Ford Community Land Trust

24 October 2024

Representations in respect of Planning Applications F/14/24, F/15/24, F/16/24

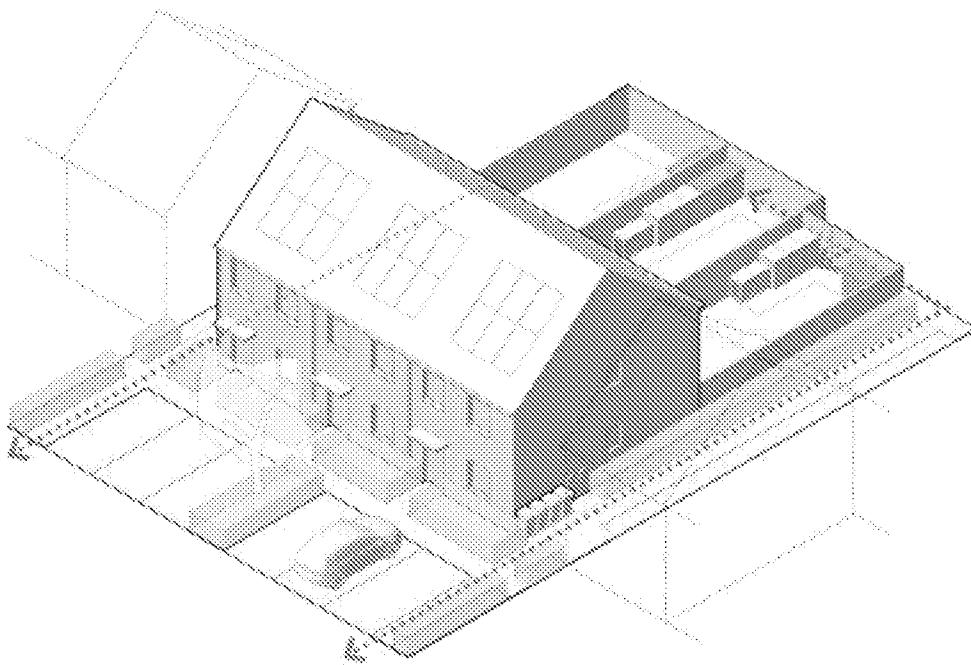
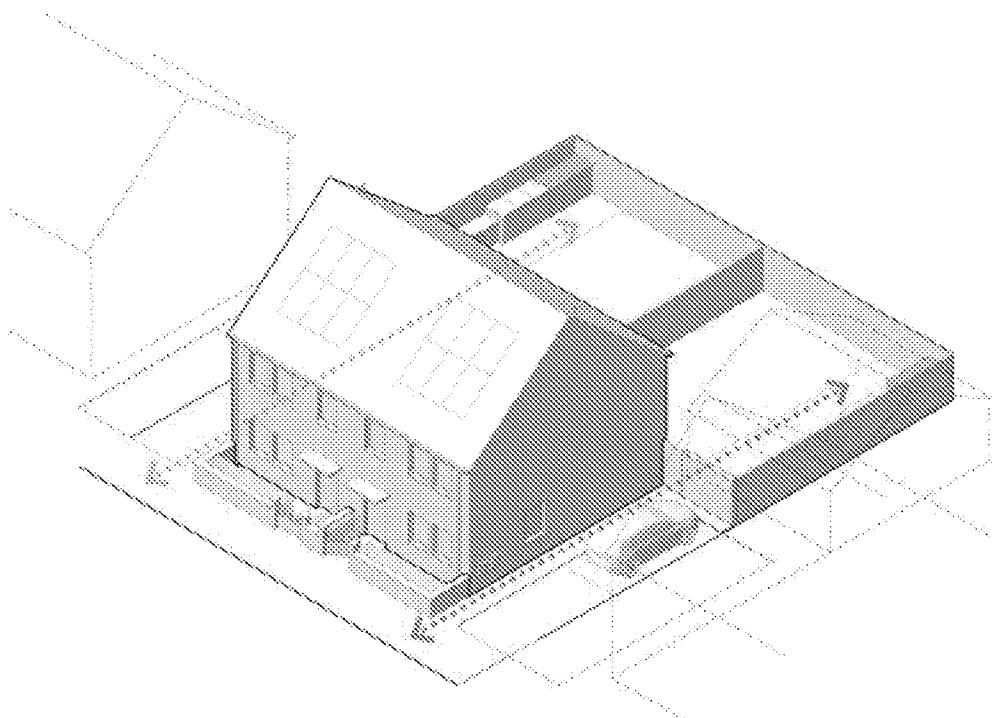
The travel plan shows alleys leading to the rear of properties where cycle stores are located. This is not good design as such alleys lead to hidden areas where antisocial behaviour can take place. Also the access alleys are only 0.8m wide which is insufficient for a person to move a cycle along.

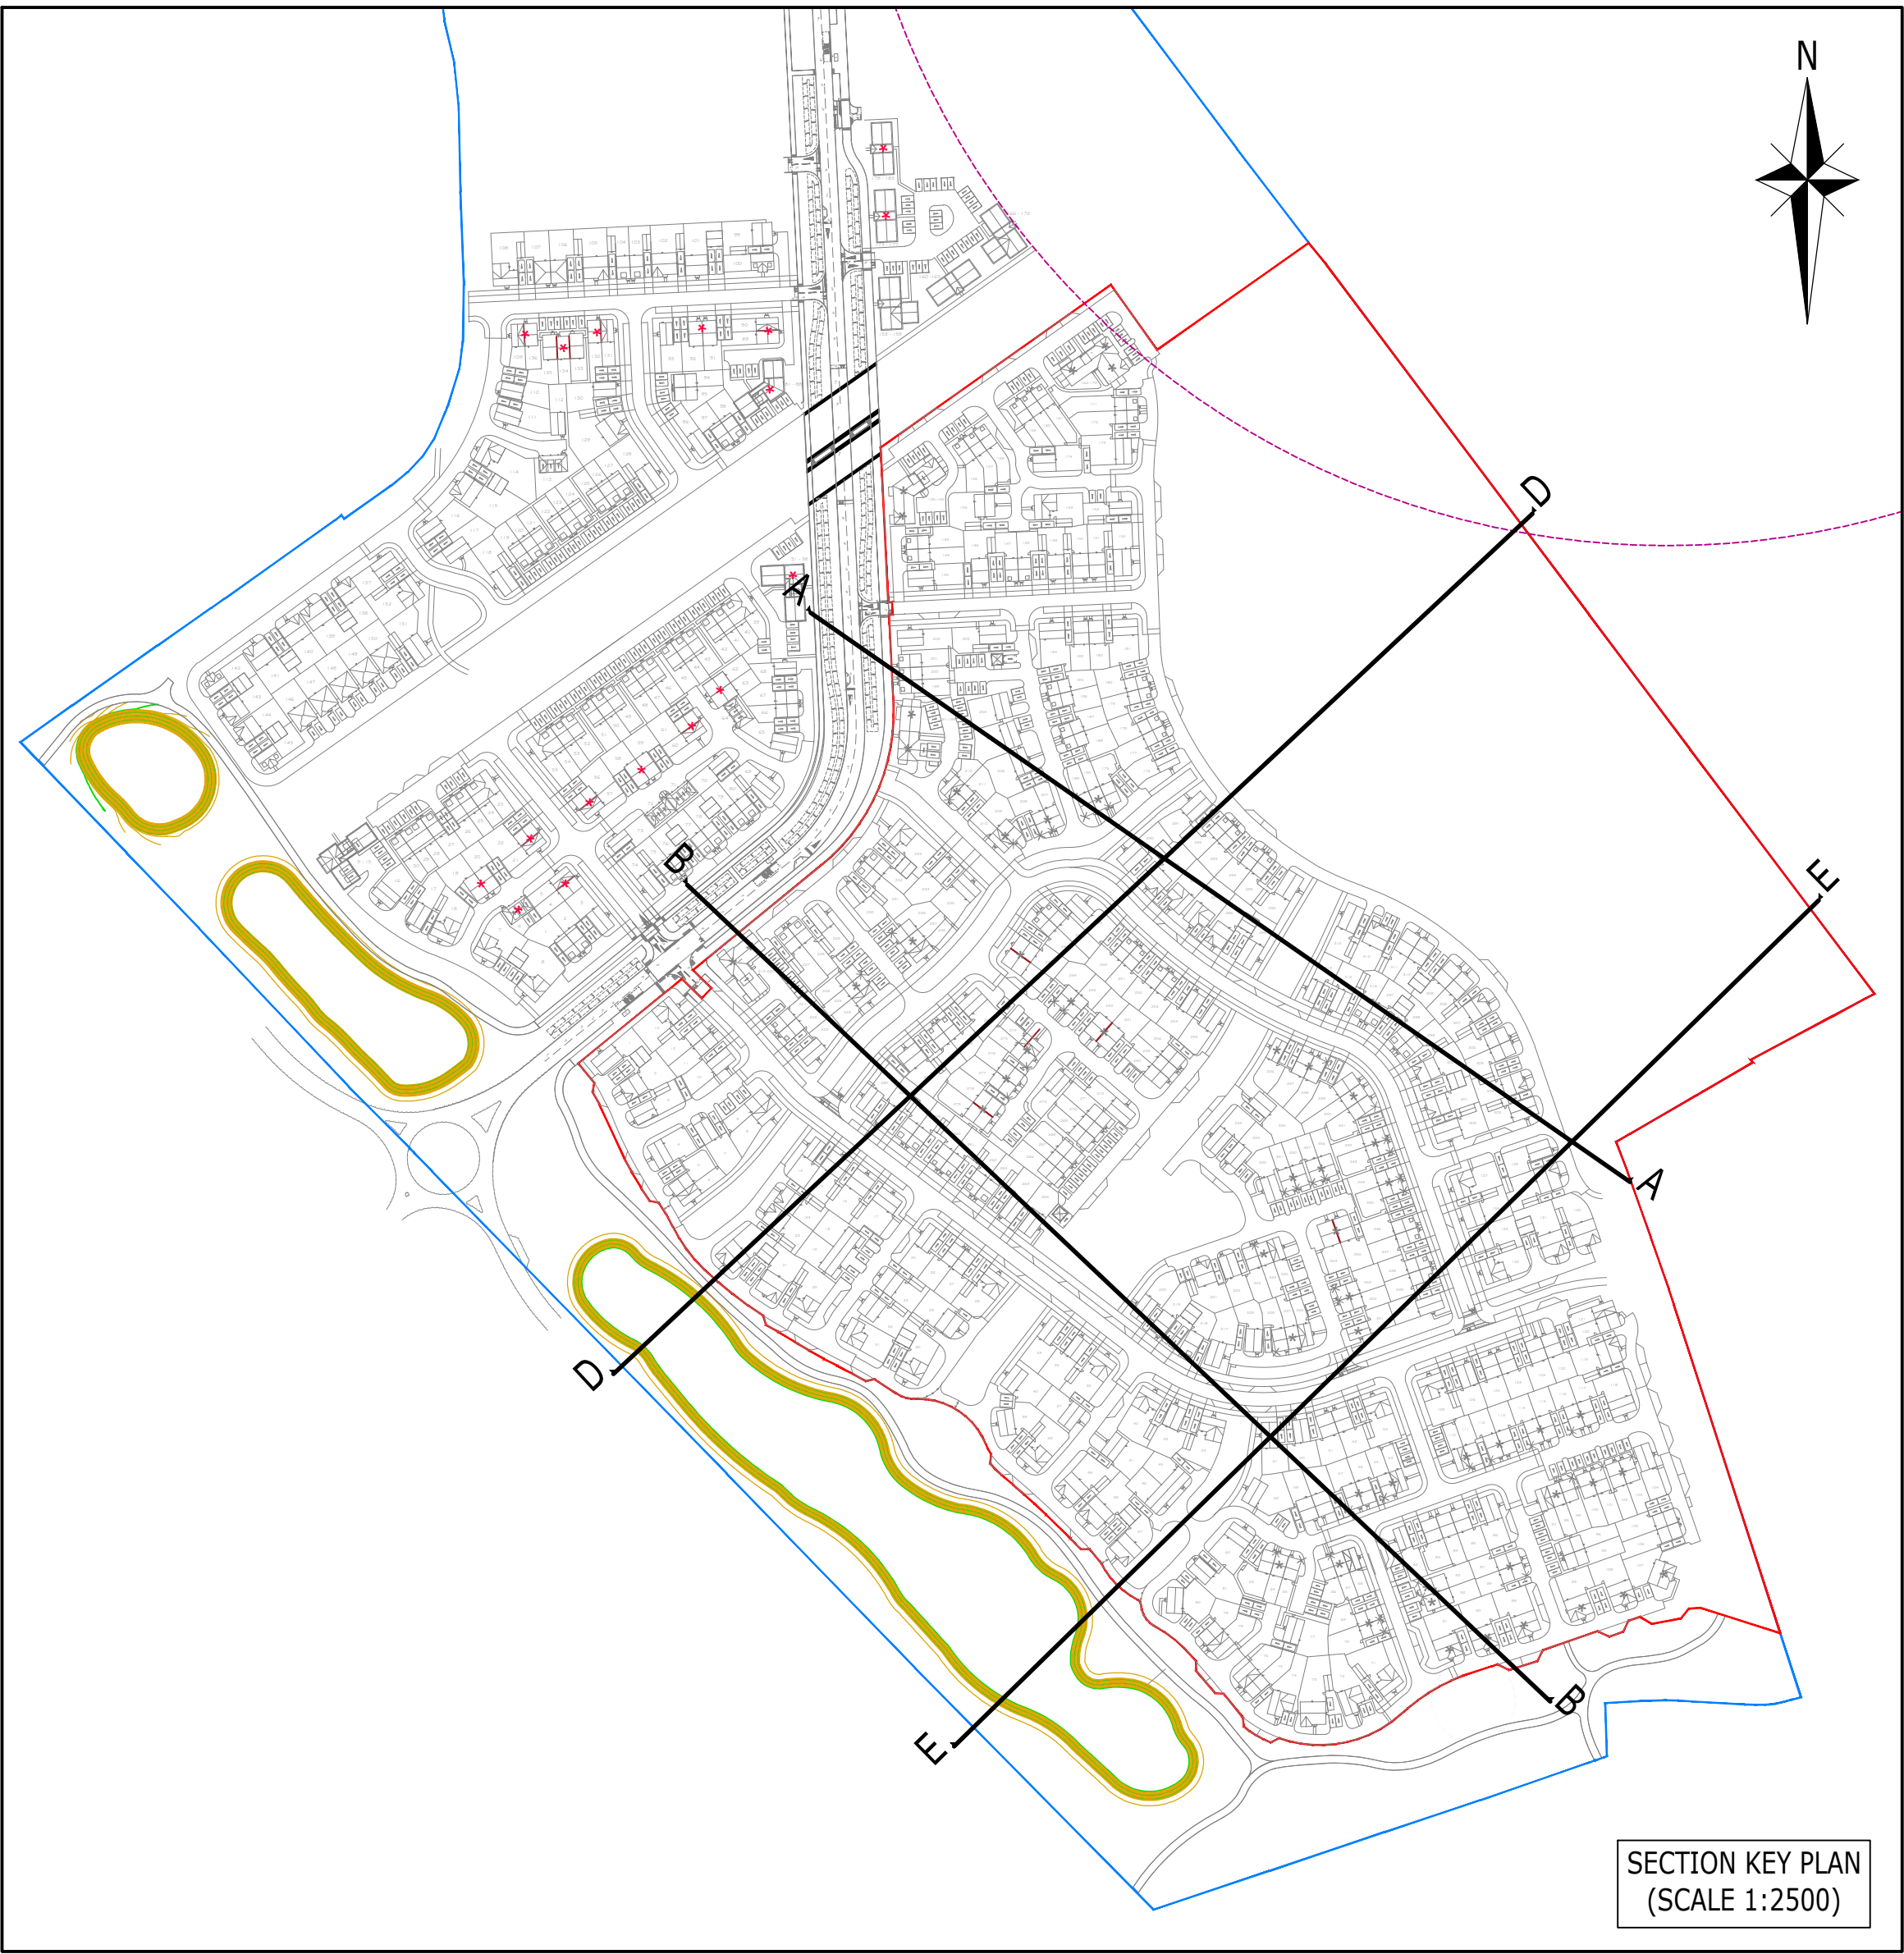
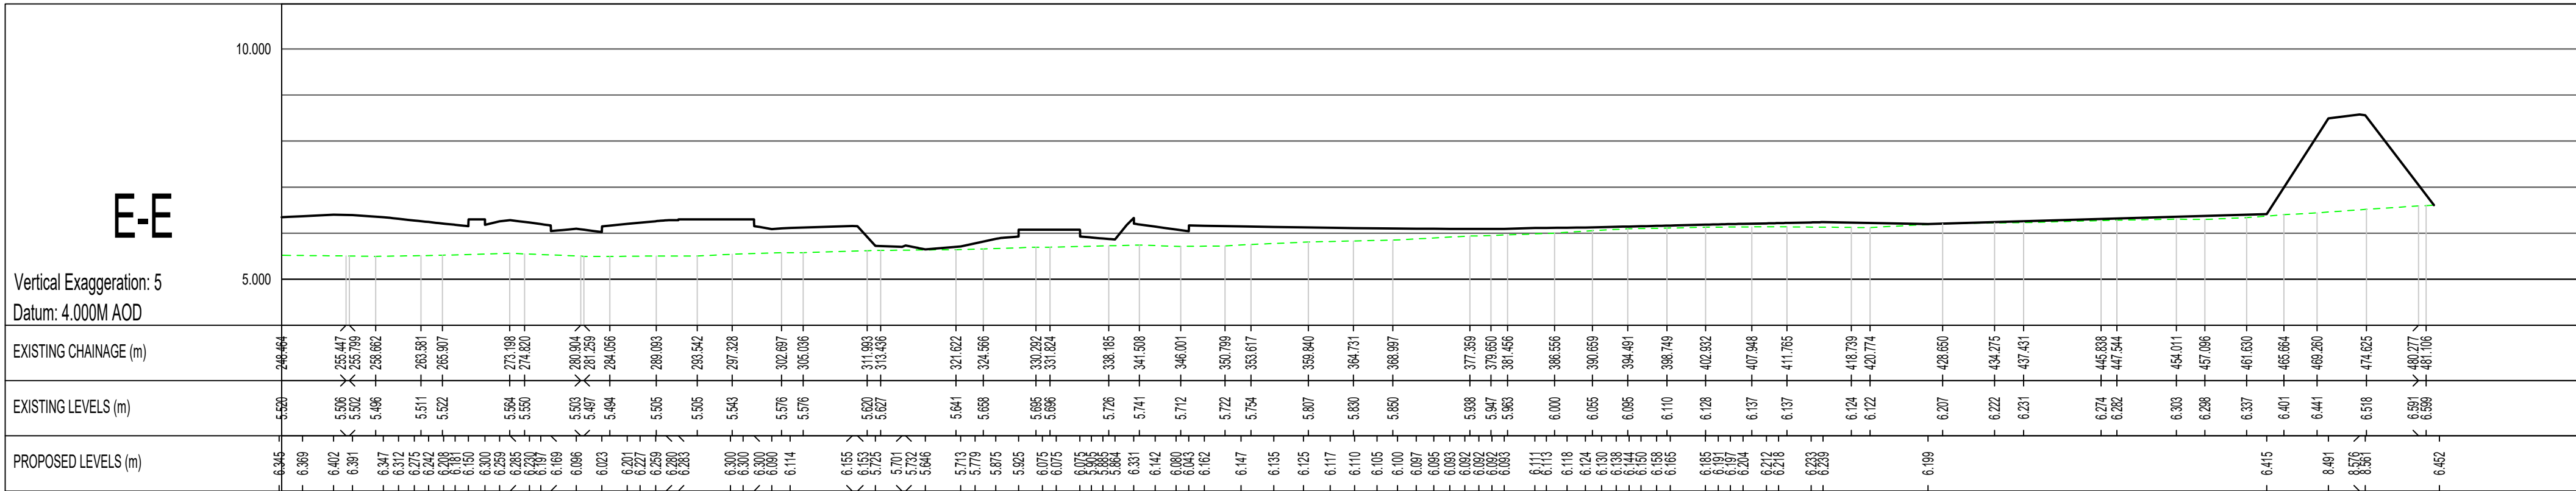
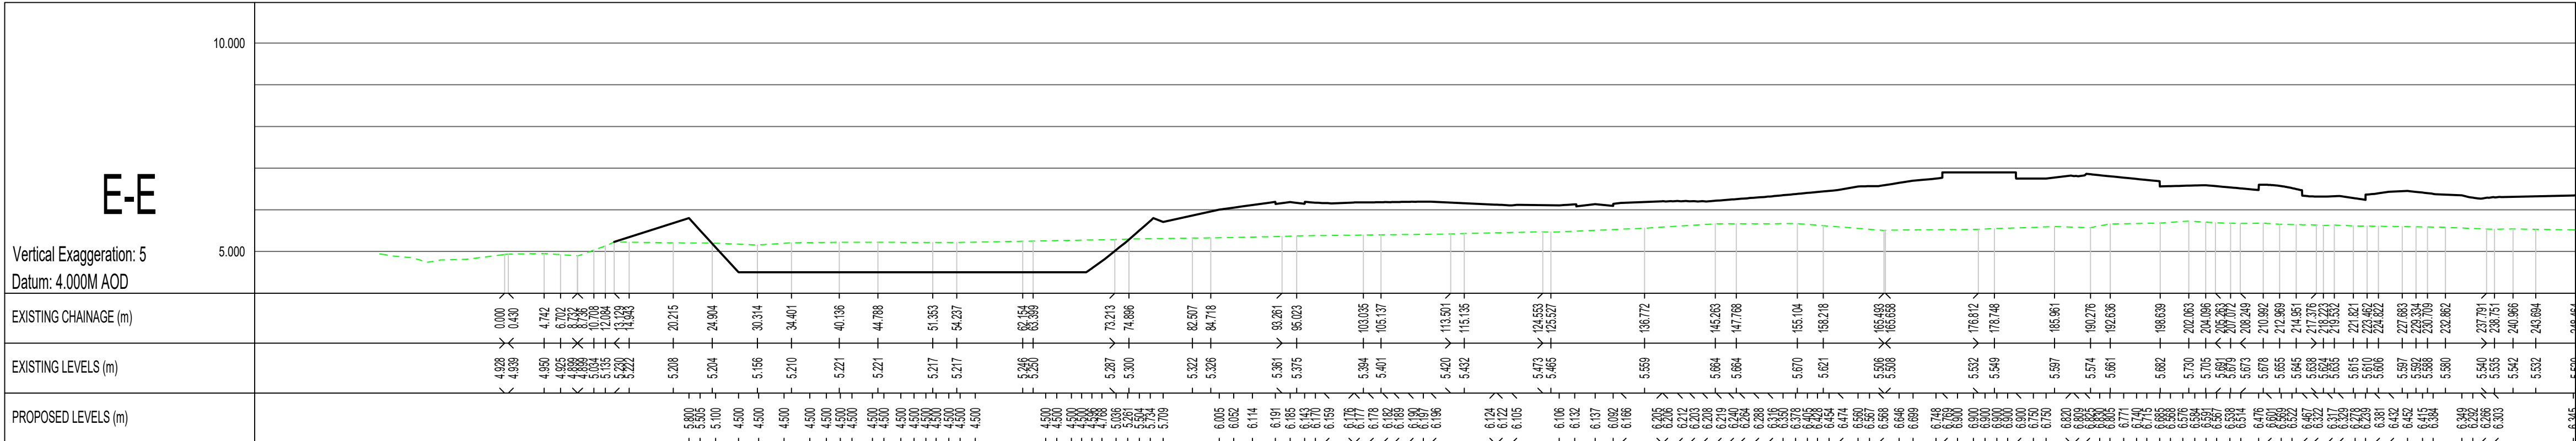
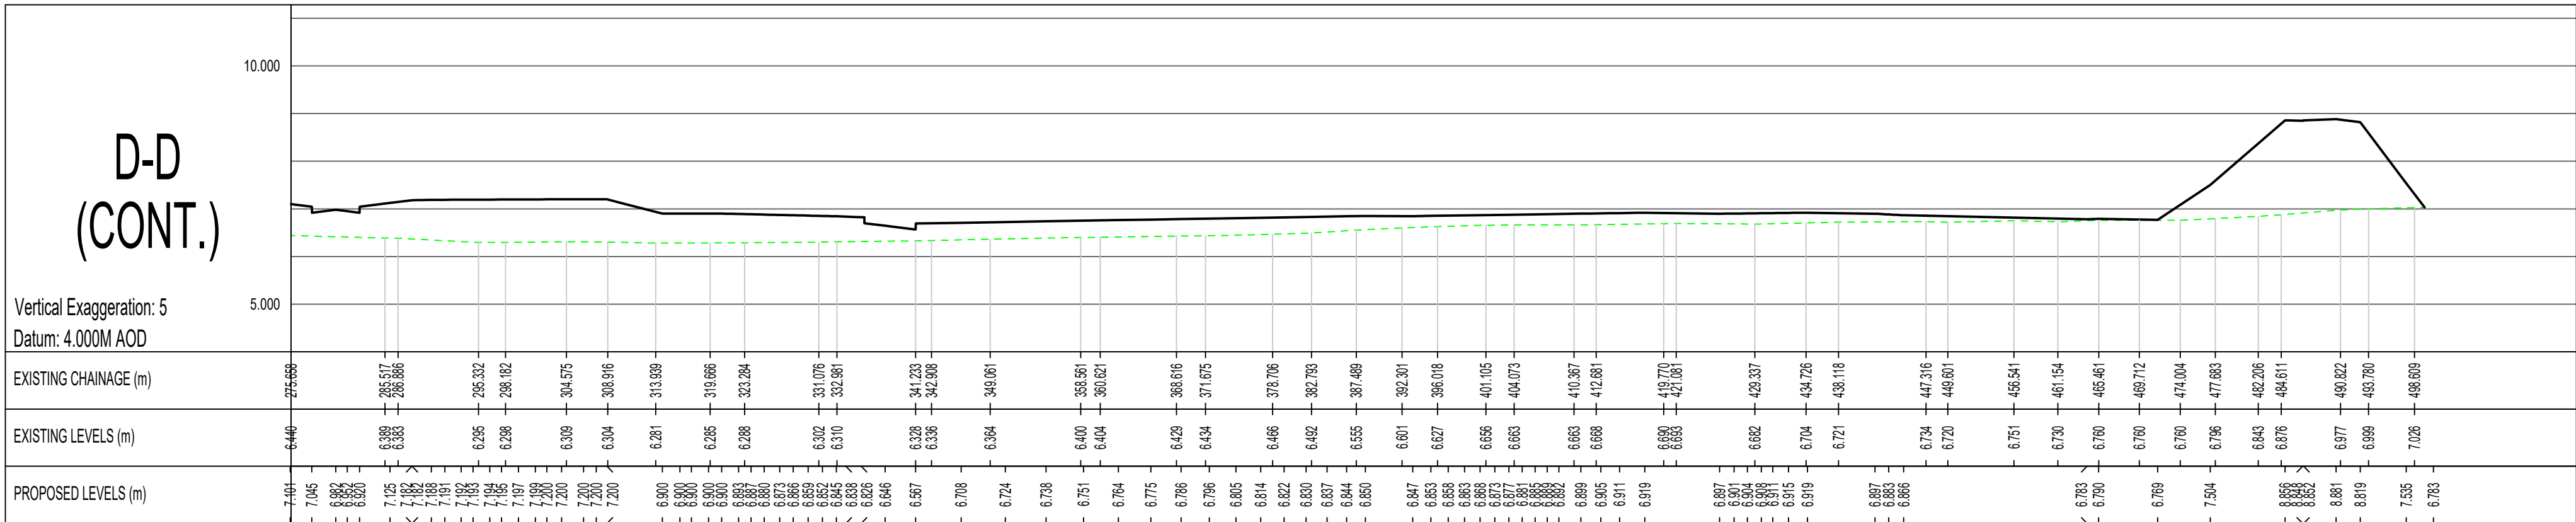
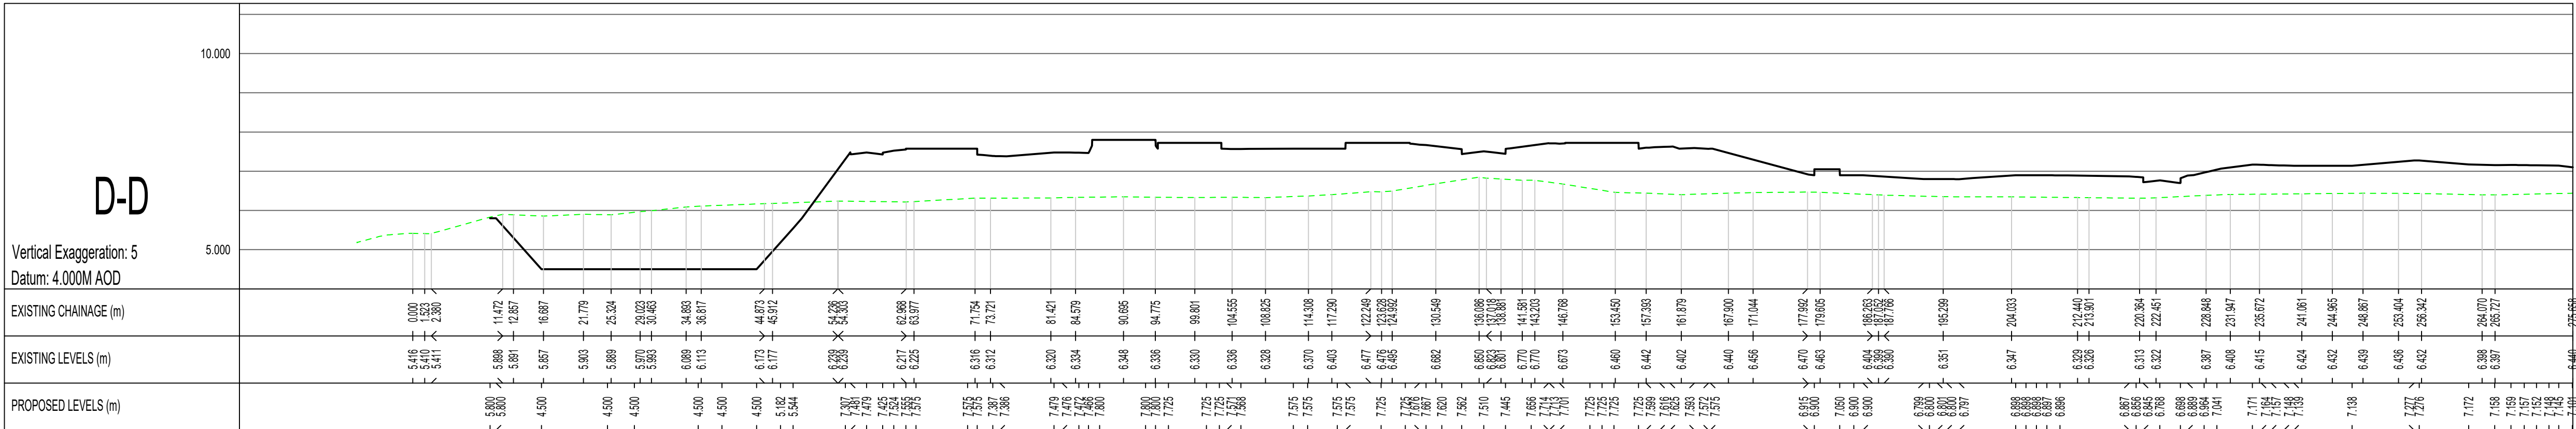
1. We assume that the size of existing surface water drain pipe under Yapton Road, adjacent to Horsemere Green junction (inset 3 drawing, plan drawing 2205771-136) is the 450mm diameter pipe indicated. Is this correct?

2. Inset drawing 2, plan 2205771-134, indicates a new 300mm SW drain pipe going across Yapton Road into an existing manhole in the field opposite. Will this pipe need pumping to get the water into the existing headwall ditch (invert level 3.59m)

3. Inset 1 drawing, plan 2205771-131, proposes a new 375mm diameter SW drain across Ford Lane into an existing ditch. Does this ditch flow northwards? If not the water will backup into the built swales within the site.
